4 No. bungalows
44 Ferringham Lane Ferring

Thank you for your internet representation made on 18th August 2017 which has been recorded as '**an objection**' with the comments as follows:

Elevations

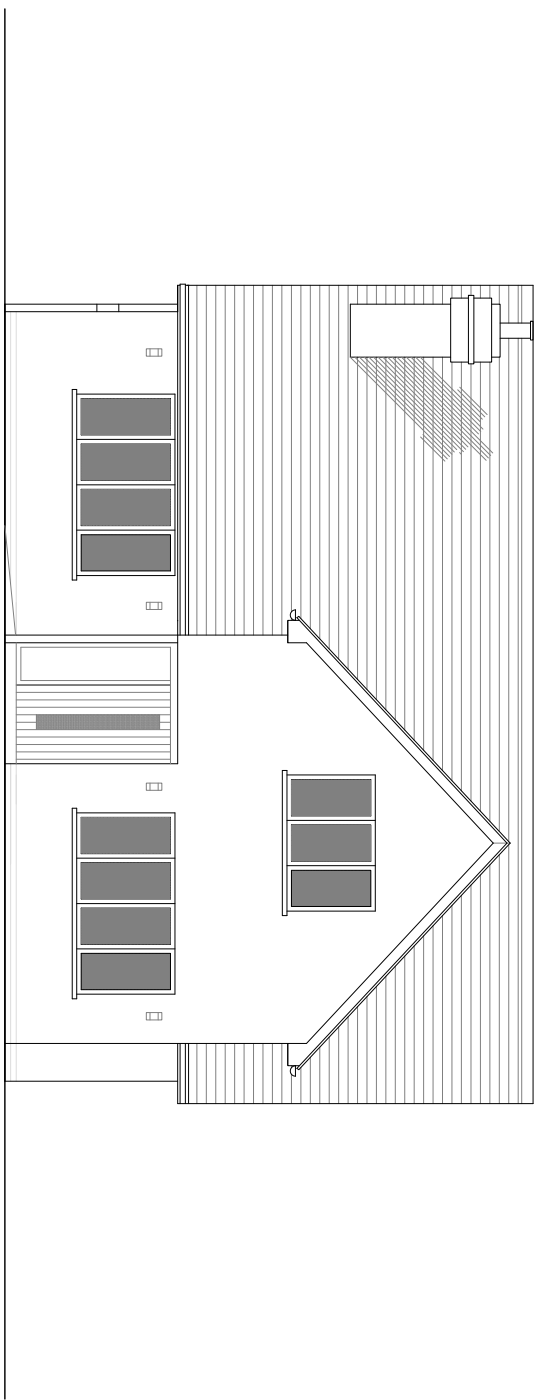
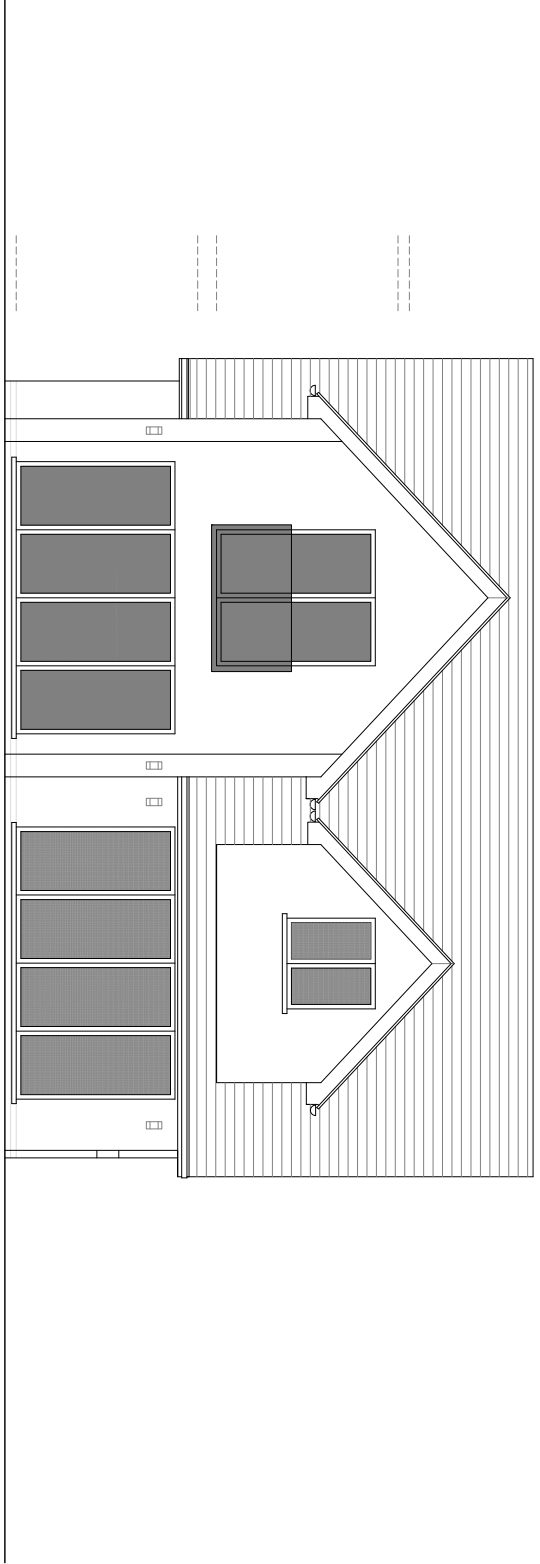
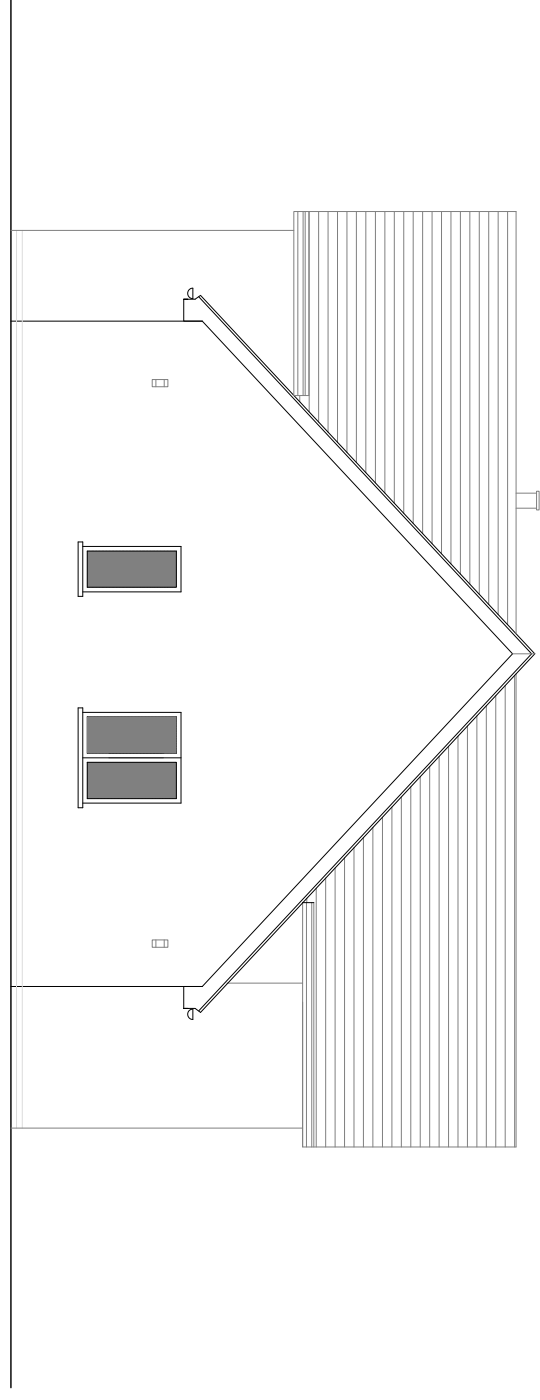
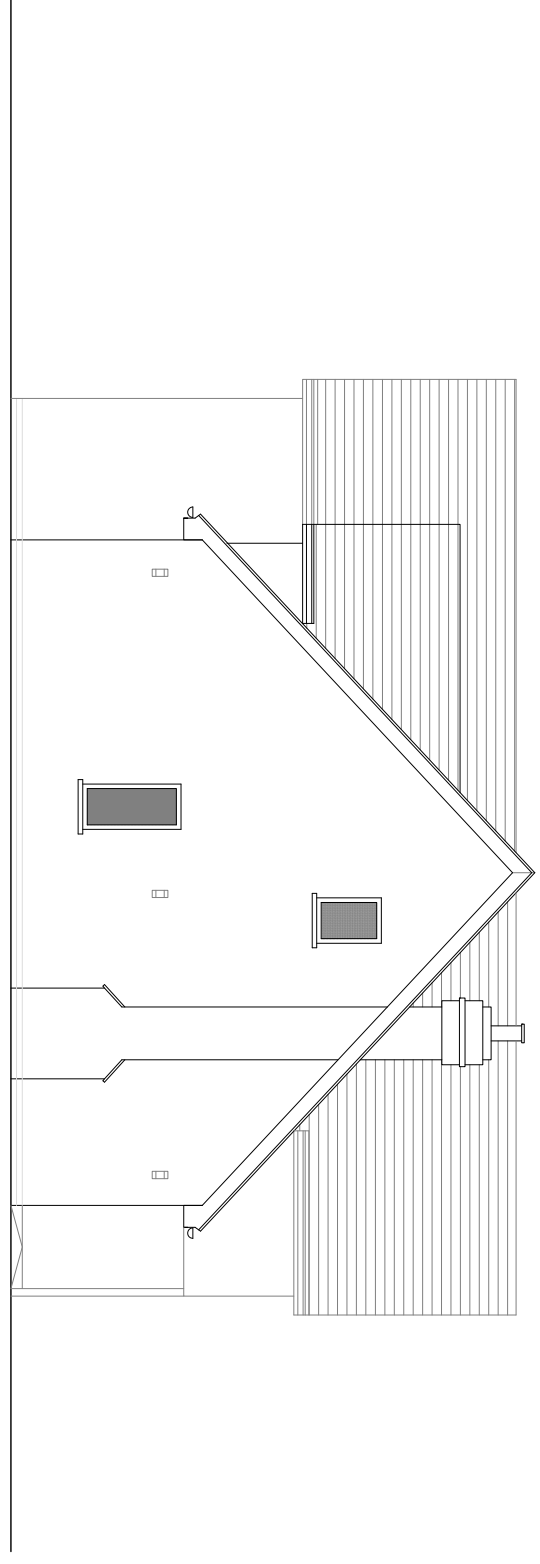
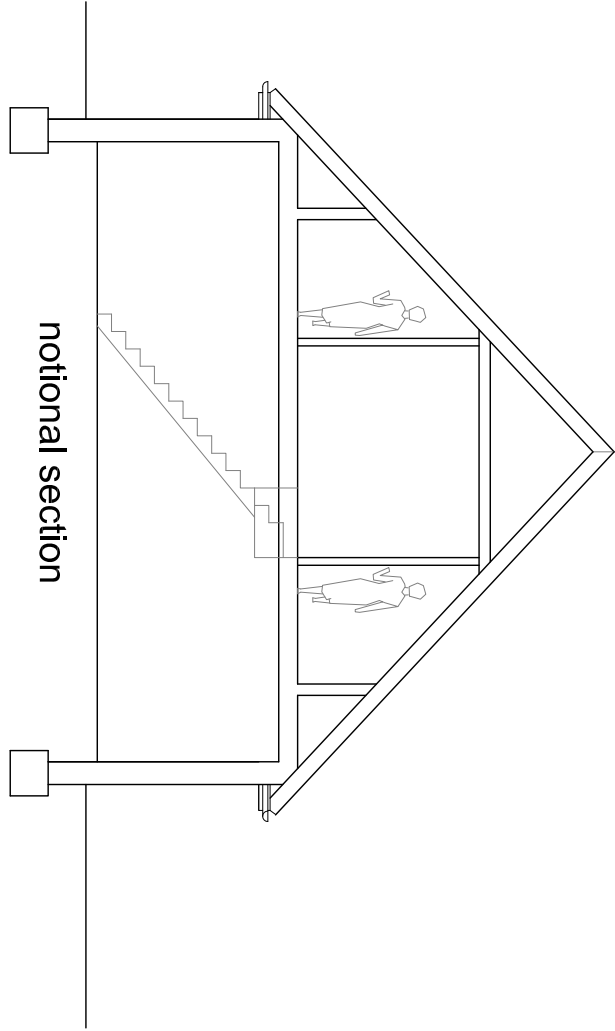
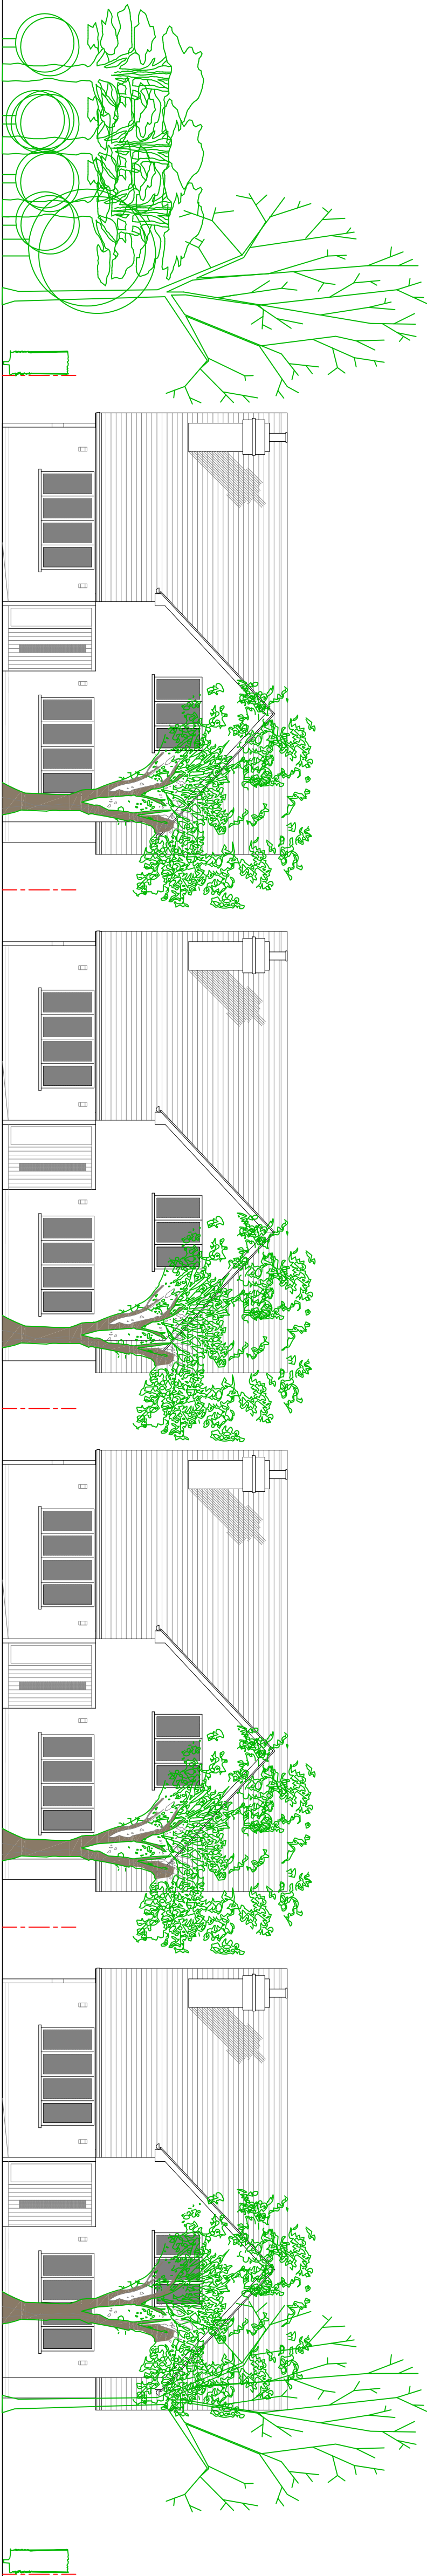
The mass, height, fenestration and Juliet balconies of the proposed houses all have an unacceptable impact on the properties to the north of the site, in Little Paddocks. Those properties will lose their privacy and quiet enjoyment of their rear gardens. - Ed Miller (Secretary, Ferring Conservation Group)
